Re: Permit Extension Request for

Project Name: Interior Renovation/ Addition

Project ID: 2015-138 / Address: 35 Pleasant Street / CBL: C39 F023001

On April 11, 2016, the Planning Authority approved with conditions a Level II site plan for a building addition to the structure at 35 Pleasant Street. The proposed building addition expands the existing residential use by adding one story to the rear of the building and expands the building over the existing parking area to create a garage and upper floor residential space. This project includes a construction analysis from the construction company outlining how the building expansion to the property lines can be achieved from the applicant's property and will not affect adjoining properties during construction. The applicant has a construction easement along the property boundary for 14 South Street. The decision is based upon the application, documents and plans as submitted by and prepared by Lauren Reiter with a revised date of 03.24.2016. The proposal was reviewed for conformance with the standards of Portland's site plan ordinance.

A101

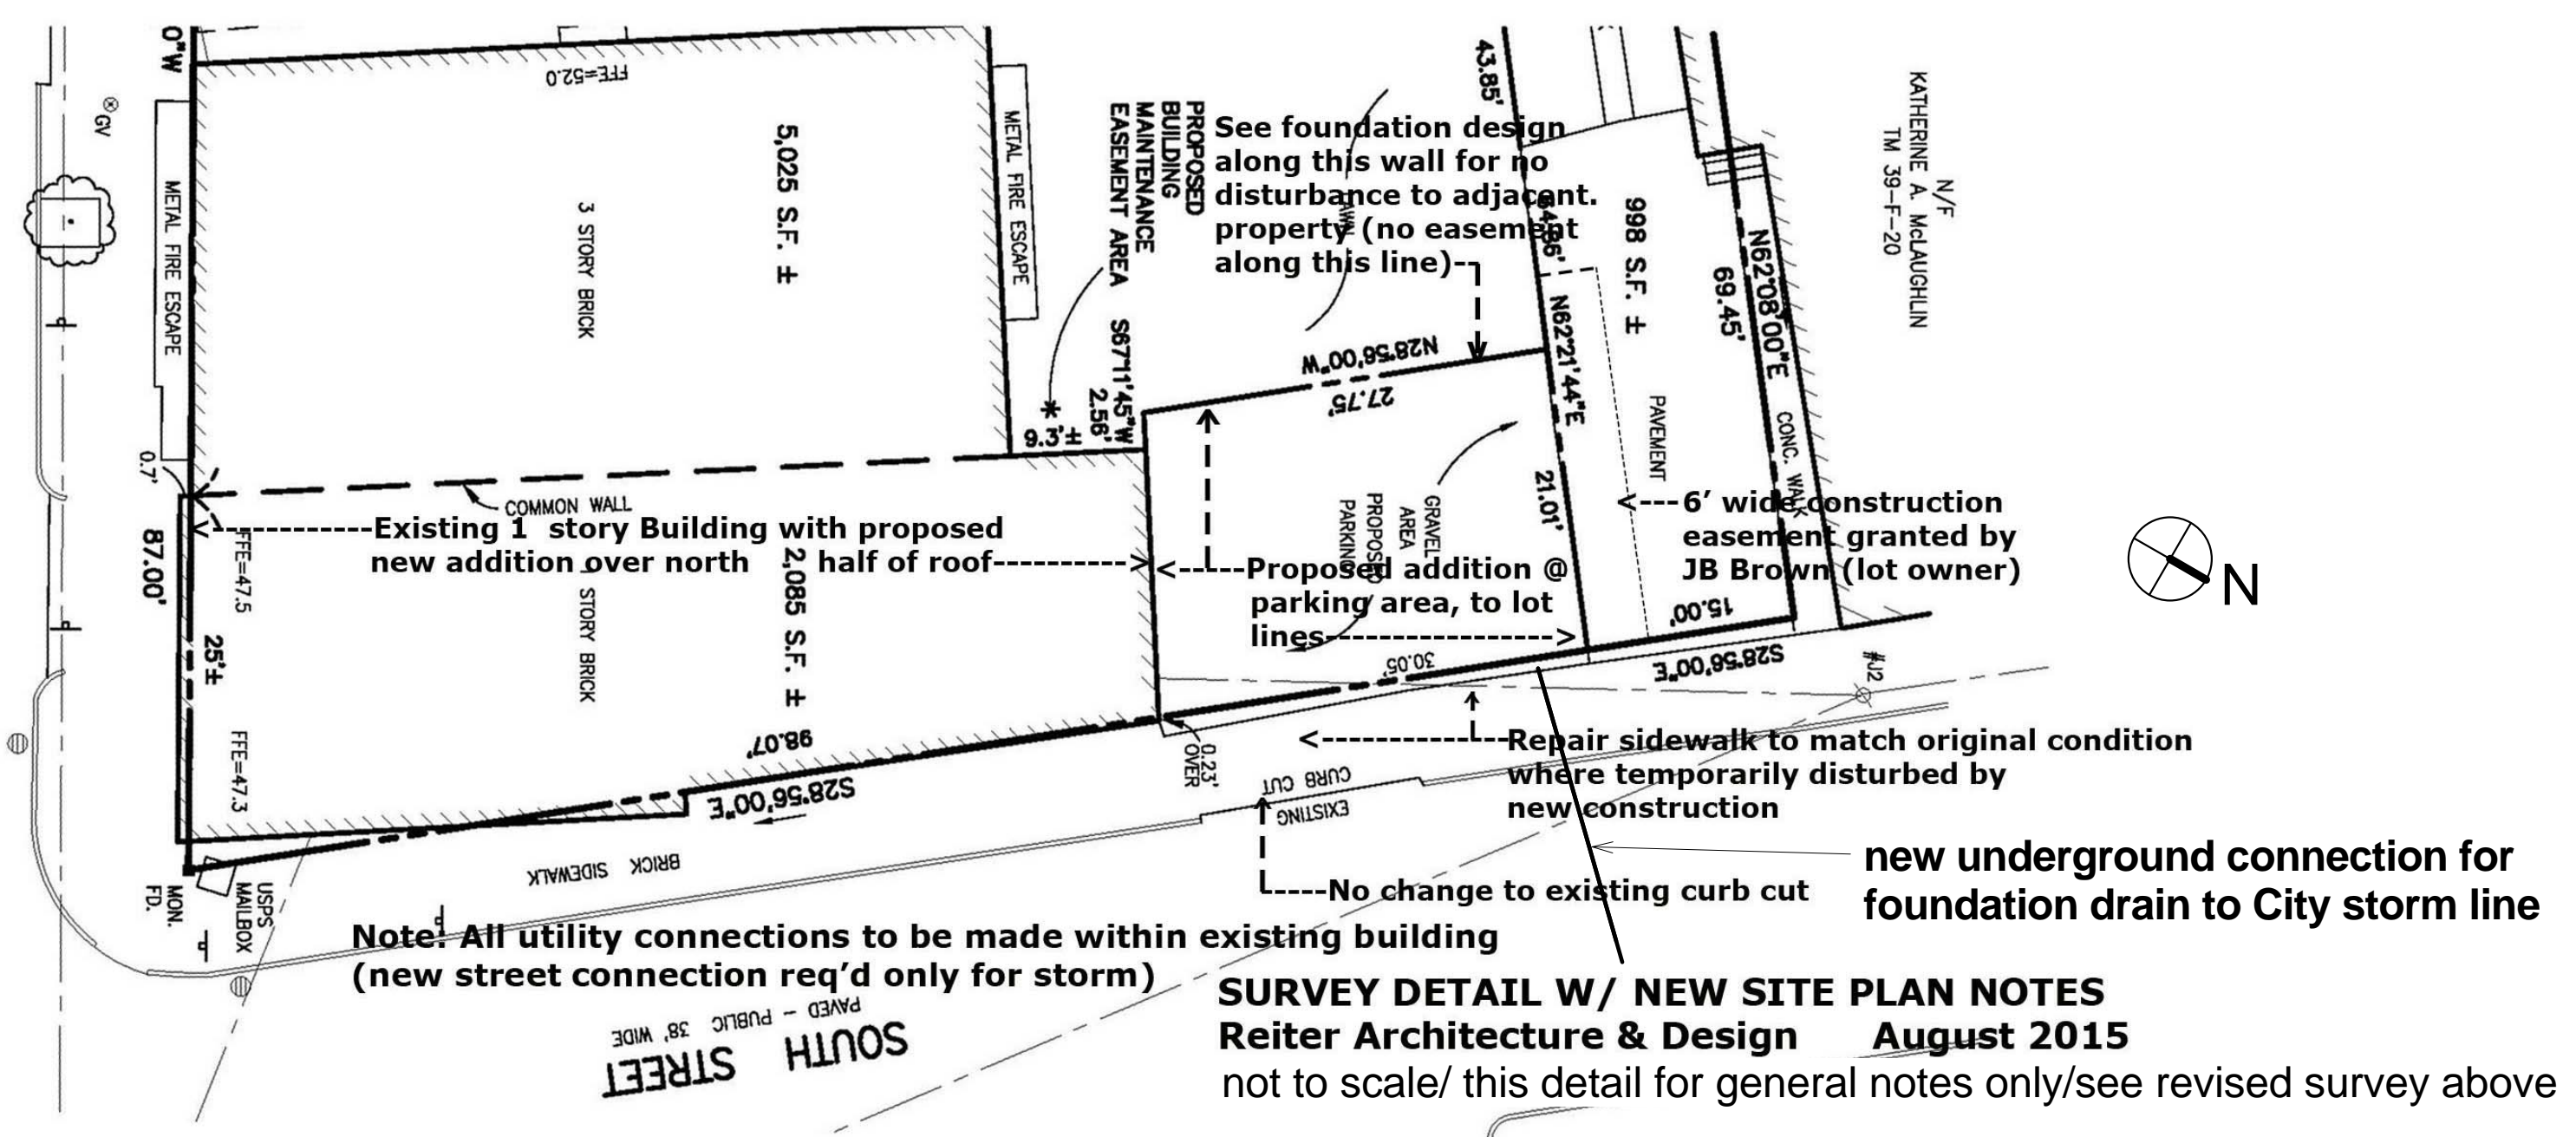
1. The applicant shall cleanly cut any disturbed roots of the Elm tree, on the abutters property at 37 Pleasant Street during construction and be watered if conditions are dry. Deadwood shall be pruned next dormant period as not to attract elm bark beetle to the new wound wood. The applicant shall follow 'best management practices', refer to <http://www.treesaregood.com/treecare/resources/ConstructionDamage.pdf>.
2. Based upon Lauren Reiter's email dated 03.28.2016, the proposed garage will be a two bay garage (the two bays on the southerly side of garage and in line with existing curb cut) for the parking of motor vehicles. The third bay closest to the northerly property line shall not be used for motor vehicle parking space. The doors for the third bay shall not swing onto the City's right-of-way.
3. The site work and general notes #1 and #4 on Plan A101 shall be deleted from the plan.
